has permission to 11x12 additional deck

AT 82 Yale St

Permit No: 05-0170 Issue Date: FEB 25 2005 CBL: 438 A010001

City of Portland, Maine - Building or Use Permit

(NEW)
 Deck
 12'-11"
 11'-0"
 8'-0" x 12'-0"
 Deck

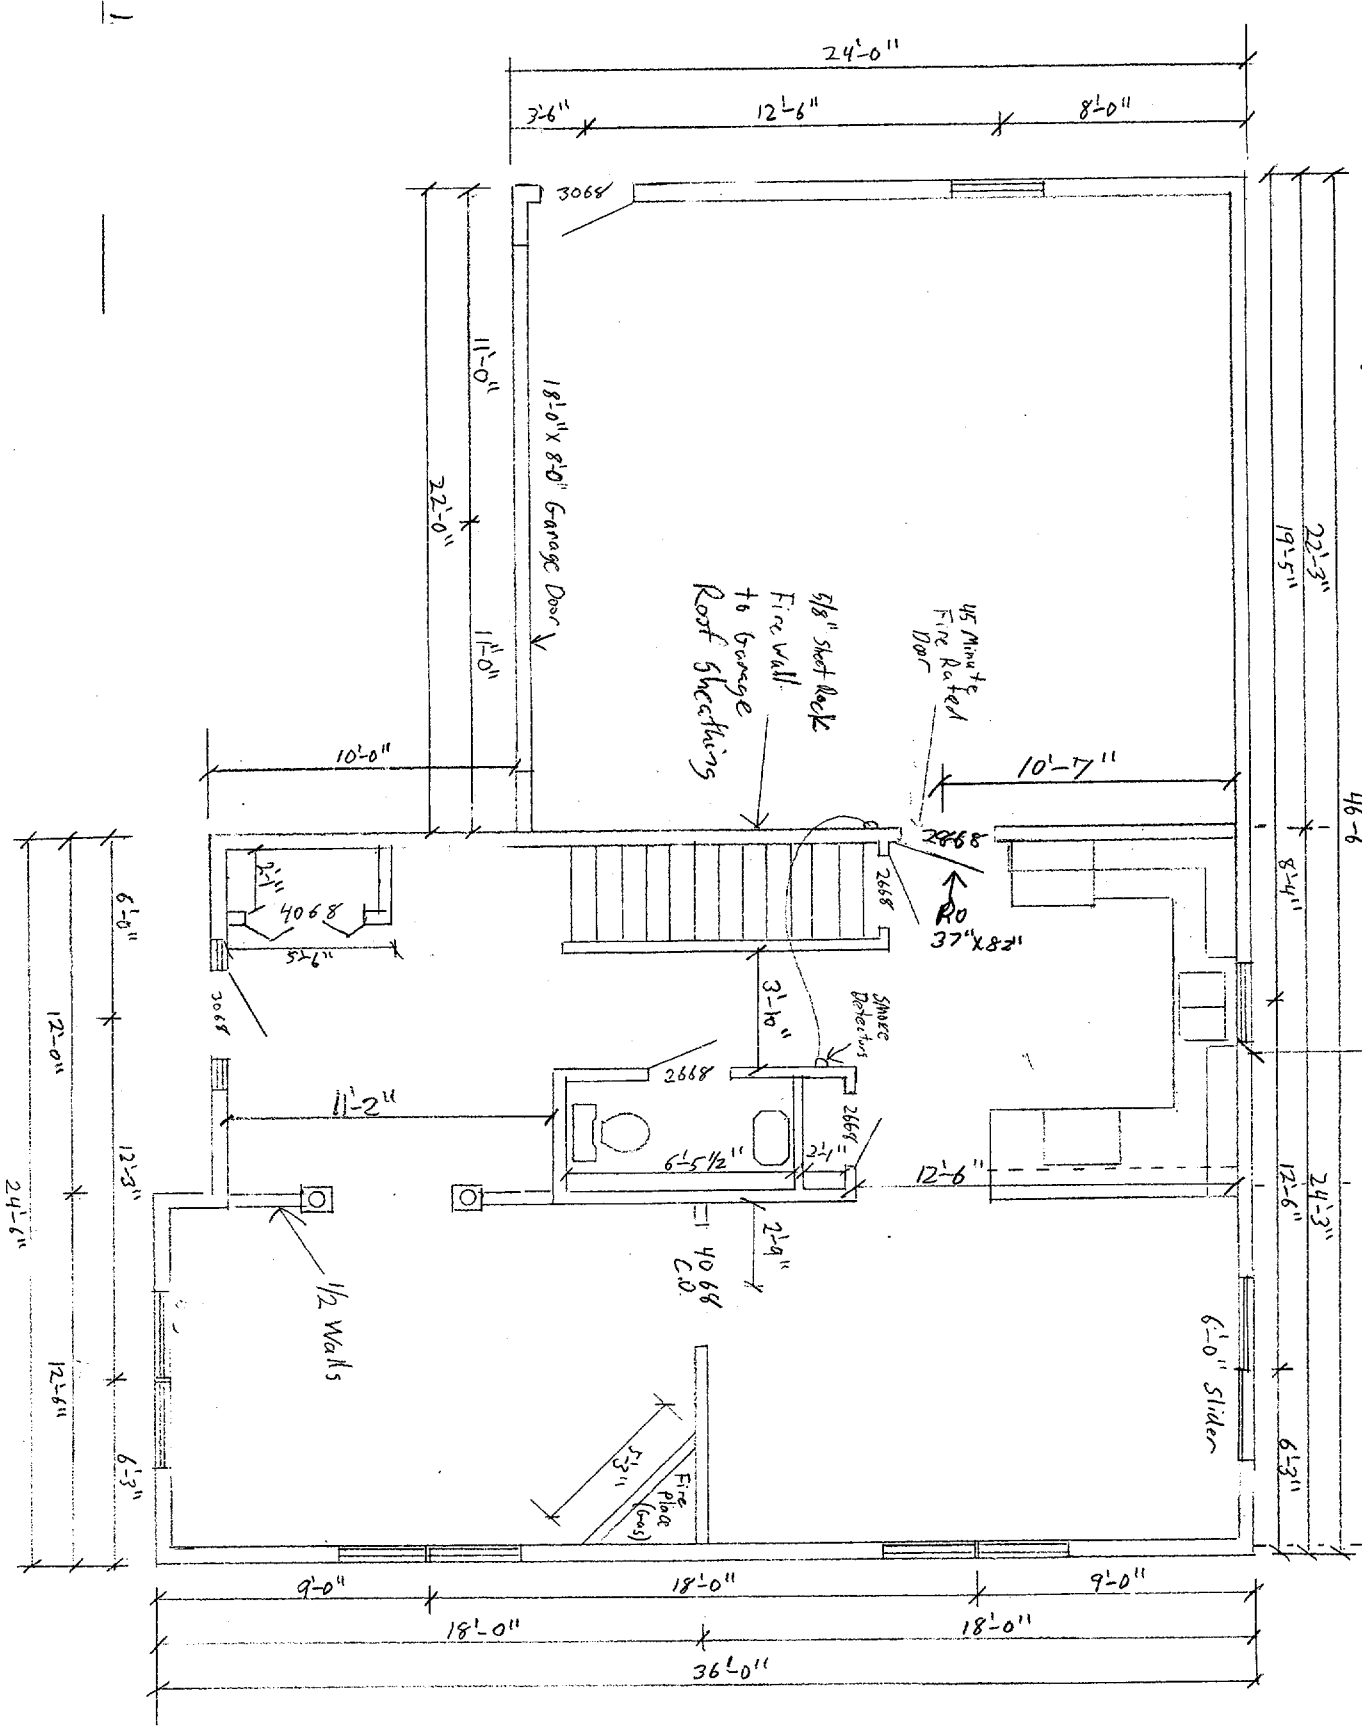
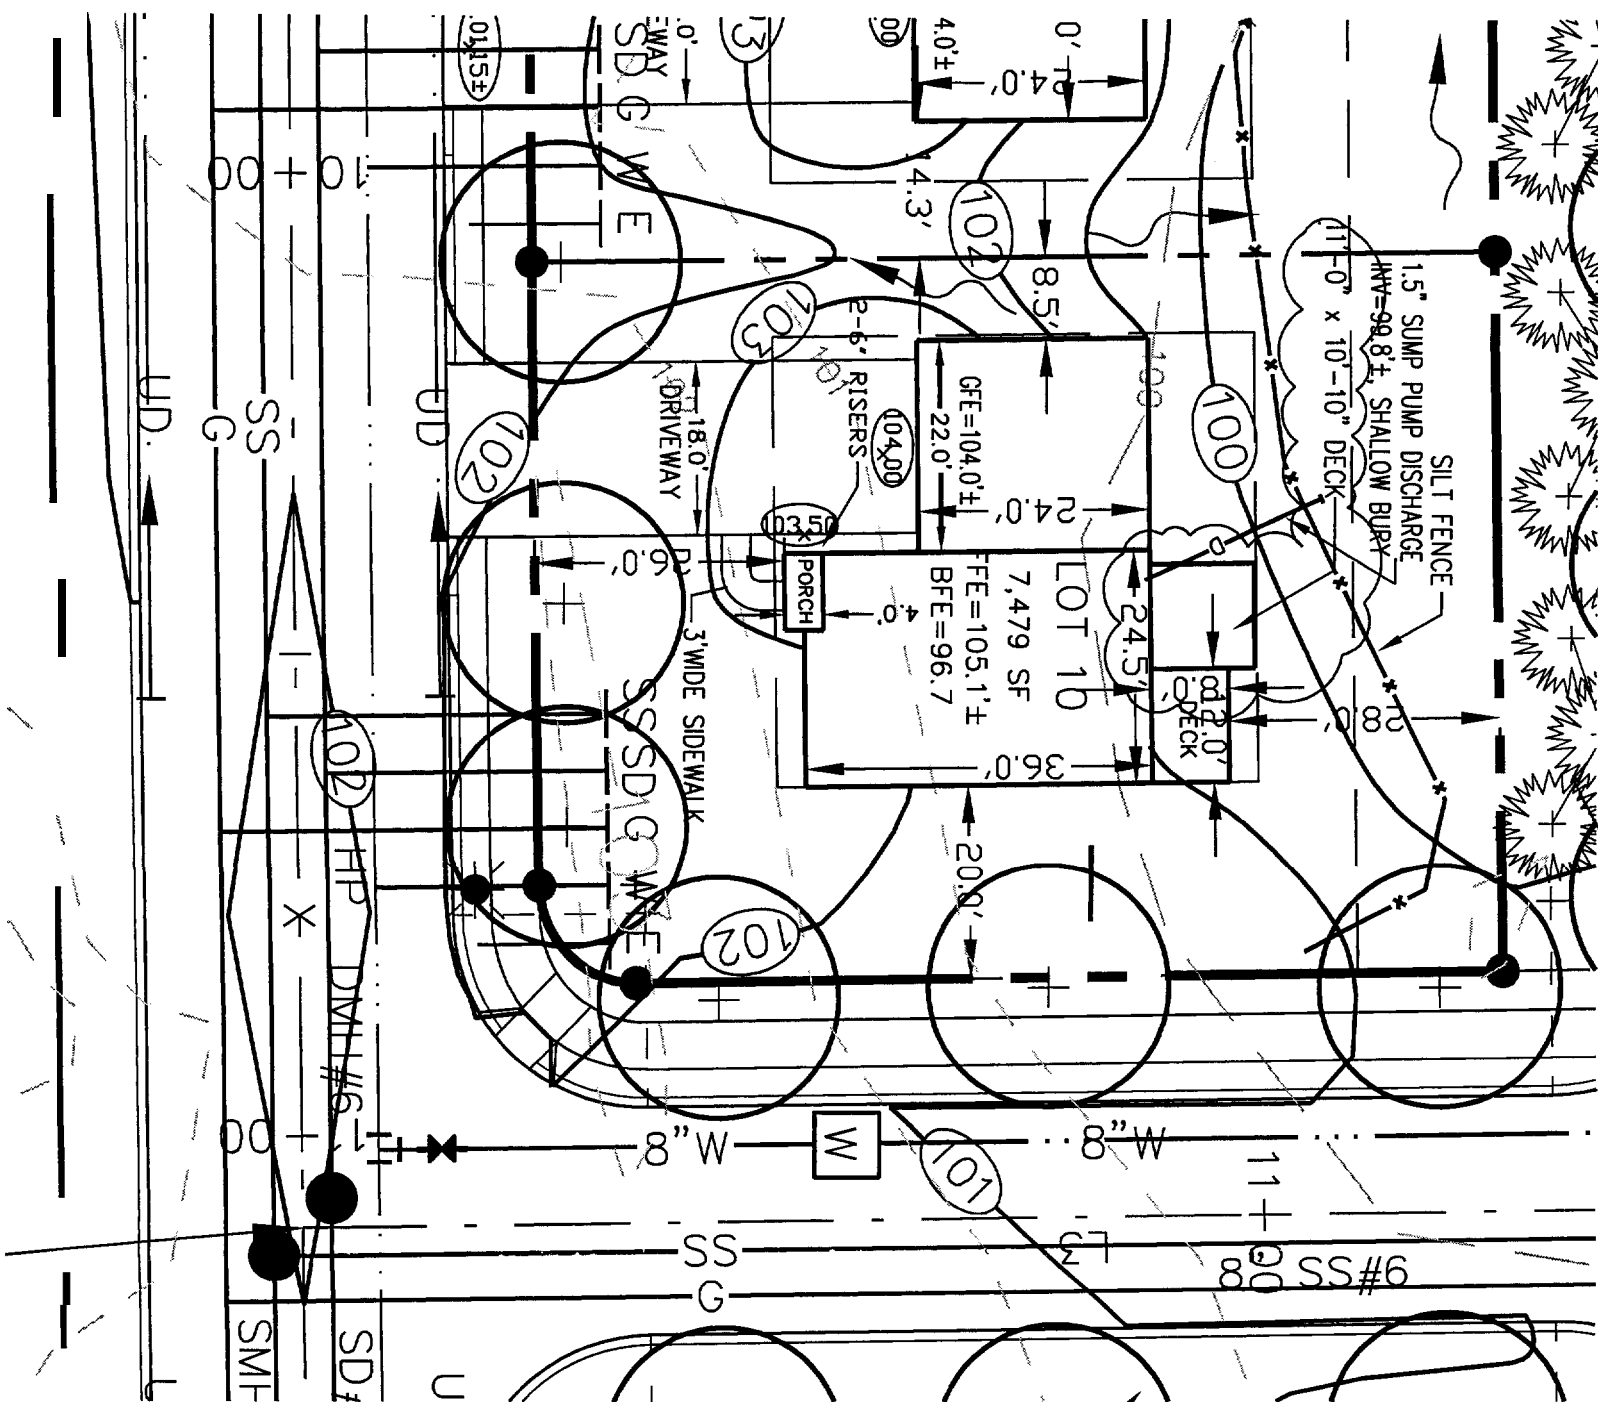
2/18/05-tmm: need framing details - called and spoke w/Chris Ballard

TITLE:
 LOT 10
 UNIVERSITY PARK
 TALE STREET
 BUILDING SITE LAYOUT

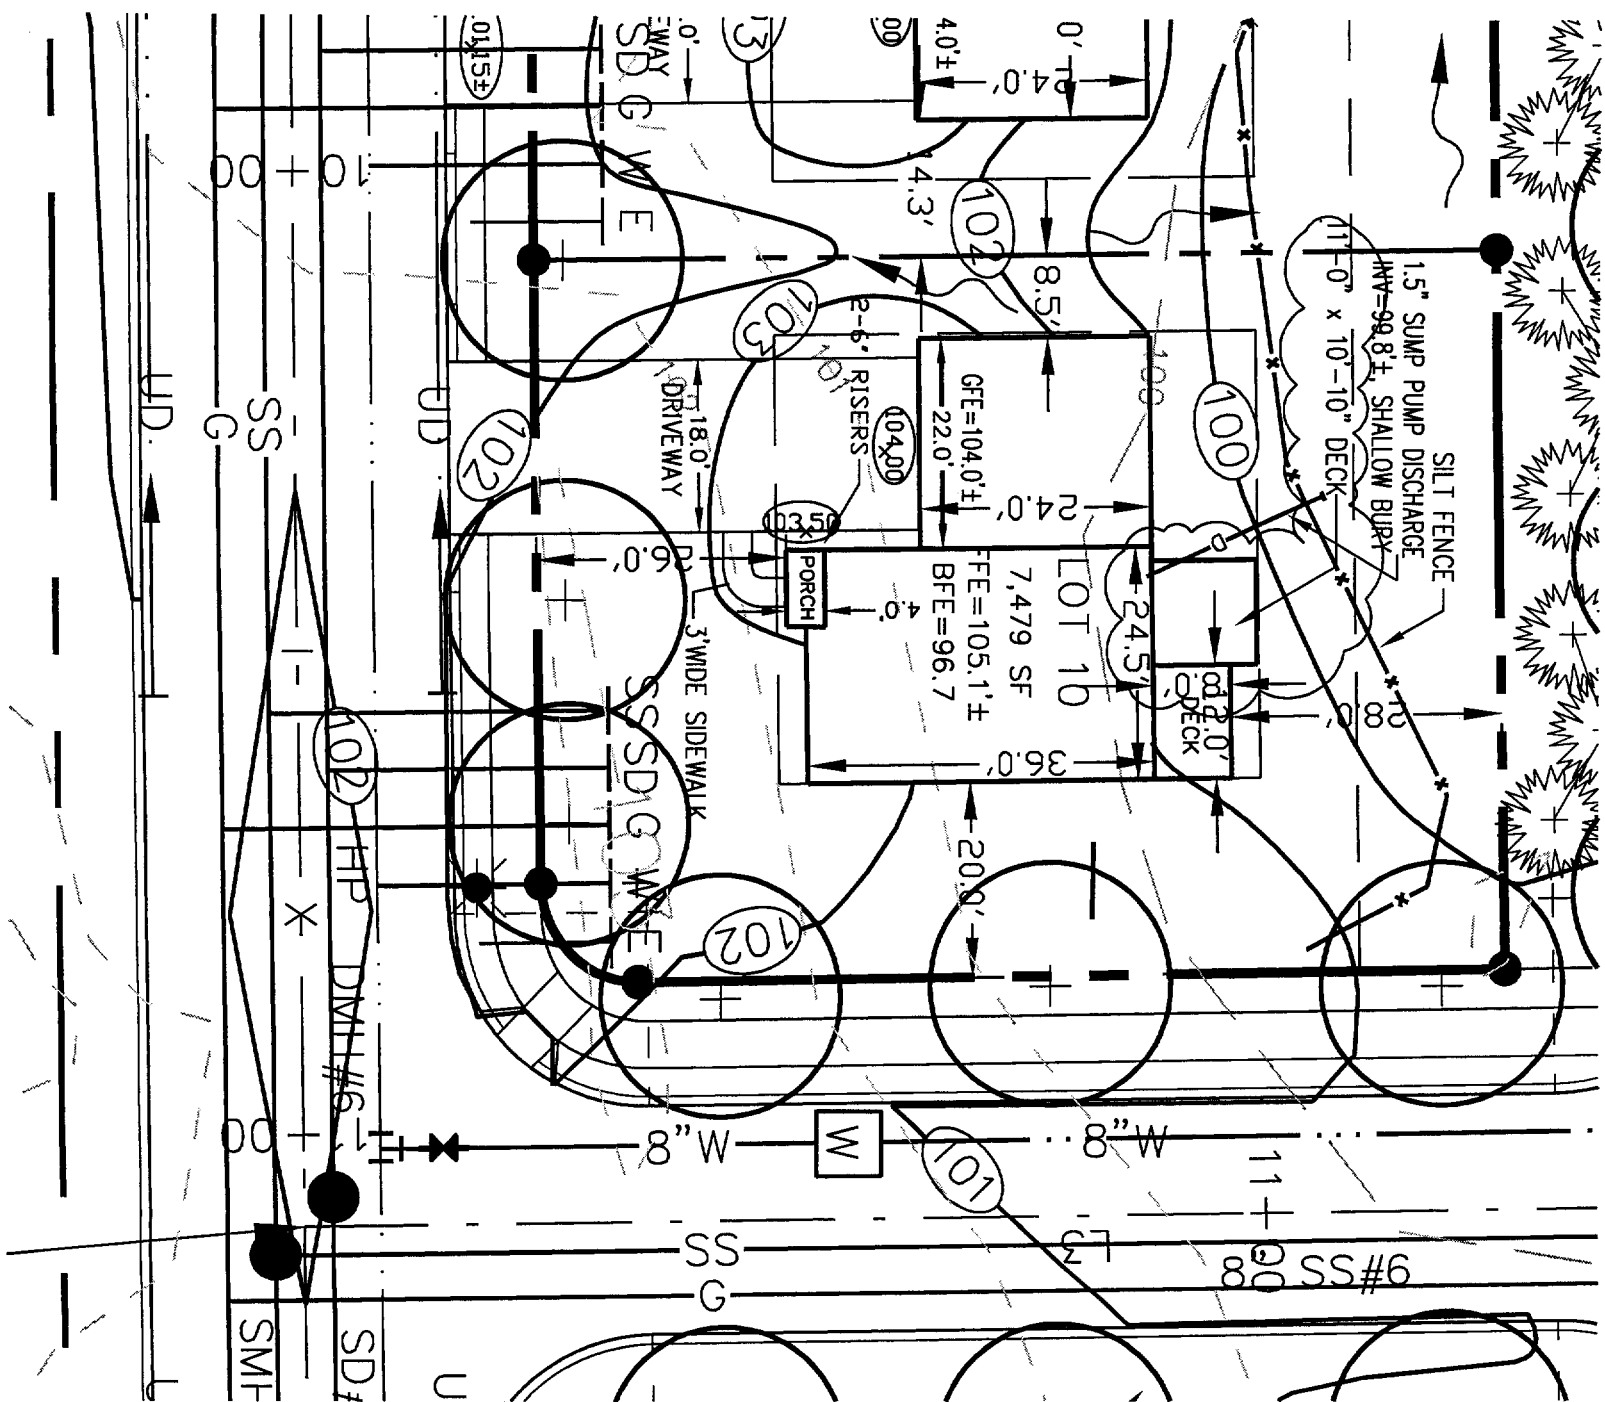
- 1) As discussed during the review process, the property must be clearly identified prior to pouring concrete and compliance with the required setbacks must be established. Due to the proximity of the setbacks of the proposed addition, it may be required to be located by a surveyor.
